From: Sarah Burrow <[REDACTED]>
Sent: 03 June 2020 09:11
To: Amber Willard <[REDACTED]>
Cc: Chris Slade <[REDACTED]> Luke Honeywill <[REDACTED]> Planning.Responses
<Planning.Responses@arun.gov.uk>
Subject: FW: BN/17/20/DOC - 3 Oriel Close

The client's Engineer forwarded me a revised Drainage Layout and Calculations yesterday after I raised concerns about the infiltration rate used. On the basis of the calculations and plan attached to this e-mail (listed below) I am happy to recommend you discharge Condition 3 on application BN/92/19/HH.

C1375_100_P1_SW Drainage Layout
SW_Network_1_A

CLIENT MR JAMES TAYLOR					
ARCHITECT CRITCHLEY ARCHITECTURE AND DESIGN LTD					
JOB TITLE 3 ORIEL CLOSE BARNHAM					
DRAWING TITLE SURFACE WATER DRAINAGE LAYOUT					
DRAWN LH	ENGINEER CS	CHECKED	APPROVED		
DATE MAY 2020	SCALE @ A1 1:100				
JOB No. C1375	STATUS P	DRAWING No. 100	REV. P1

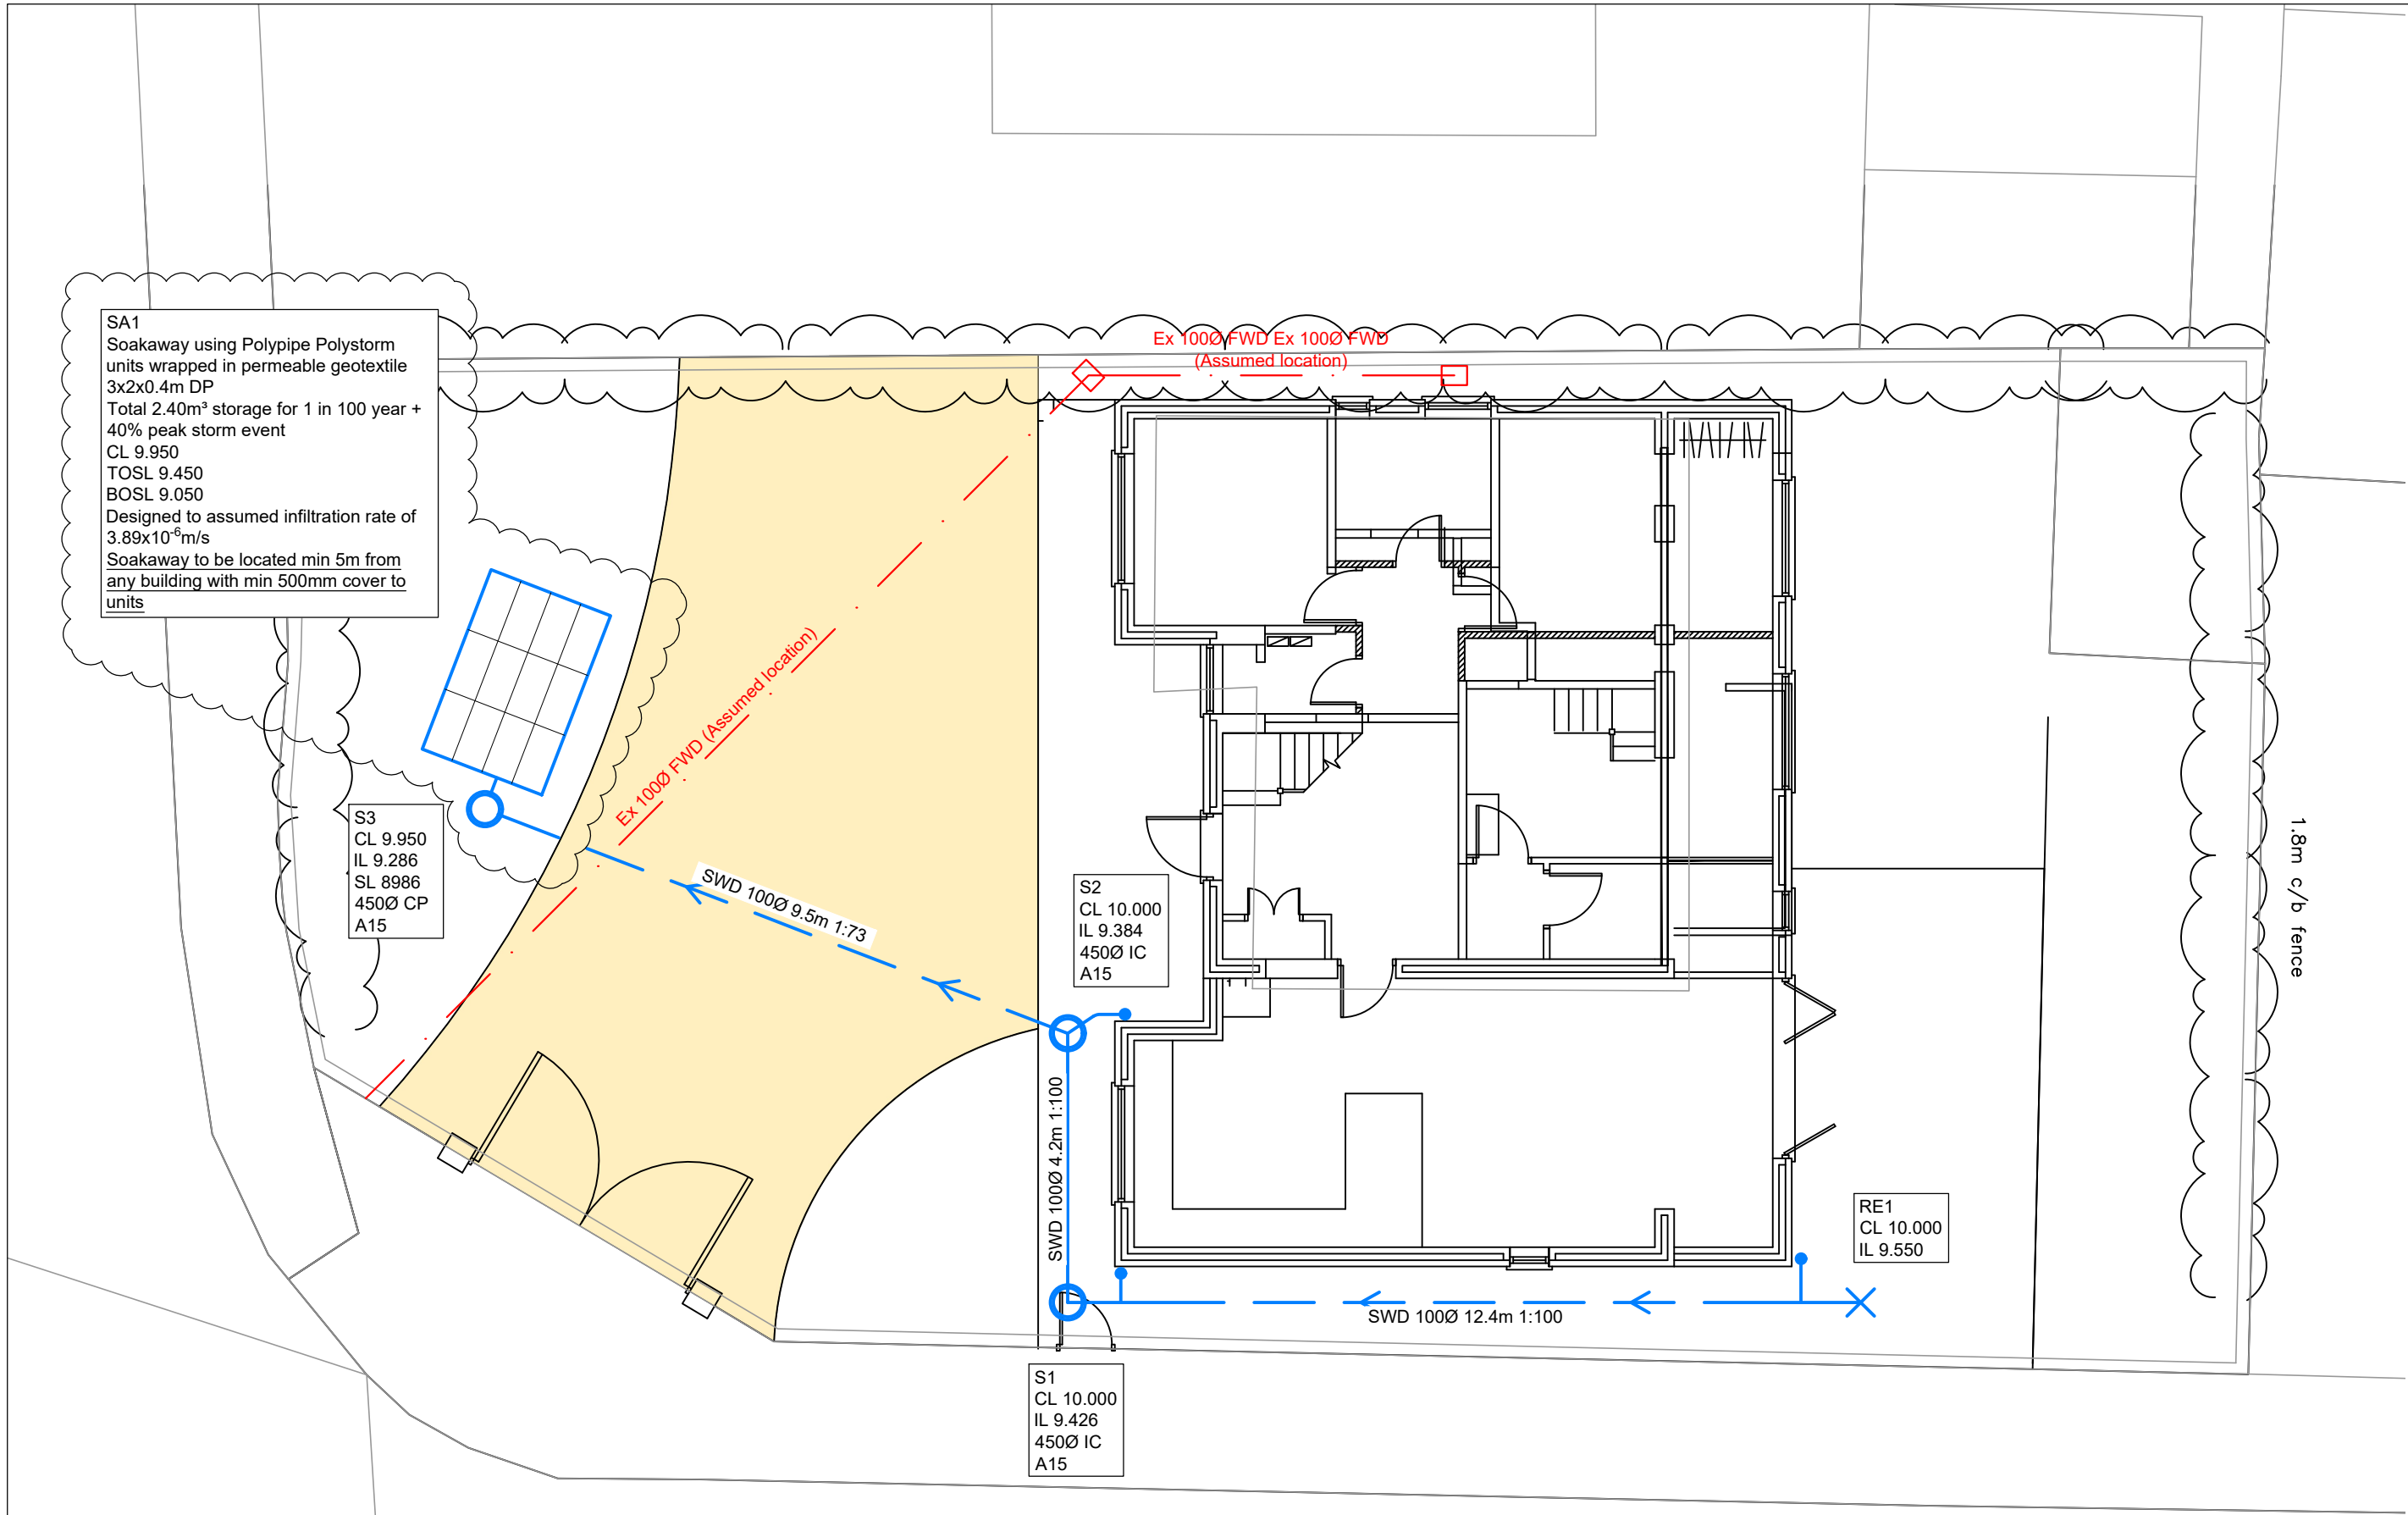
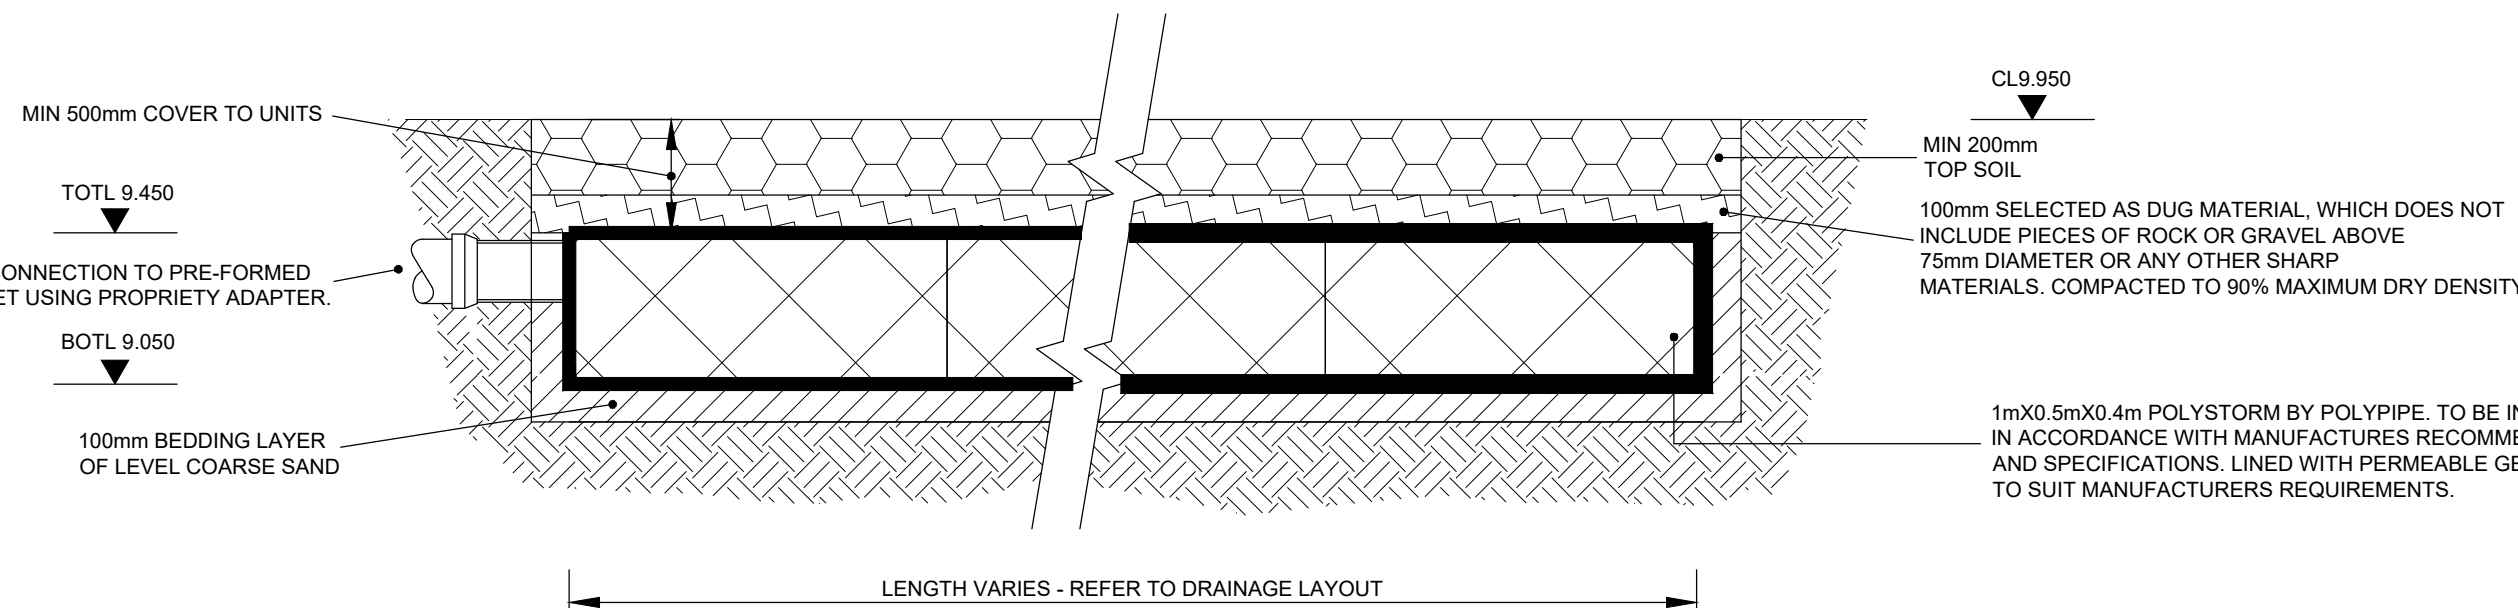
As discussed I think you are going to have to use a more conservative infiltration rate for the calculations which will result in a larger soakaway.

“Dispersal rate from on site percolation testing
300x300 pit, 320 mins to drop 150mm 0.014M³/M²/h” [sic]

On this basis I'd assume the infiltration rate to be 3.89 x 10⁻⁶m/s. However I questioned this rate at the time as the date of testing was not supplied, nor was it clear the depth of the pit or number of fills. I would have expected a factor of safety of three to be applied to this rate if the further information could not be supplied. Given the potentially very high groundwater and the ambiguity on the site the additional capacity is necessary.

Many thanks for looking at this so quickly. Please find revised drawing and calcs attached.
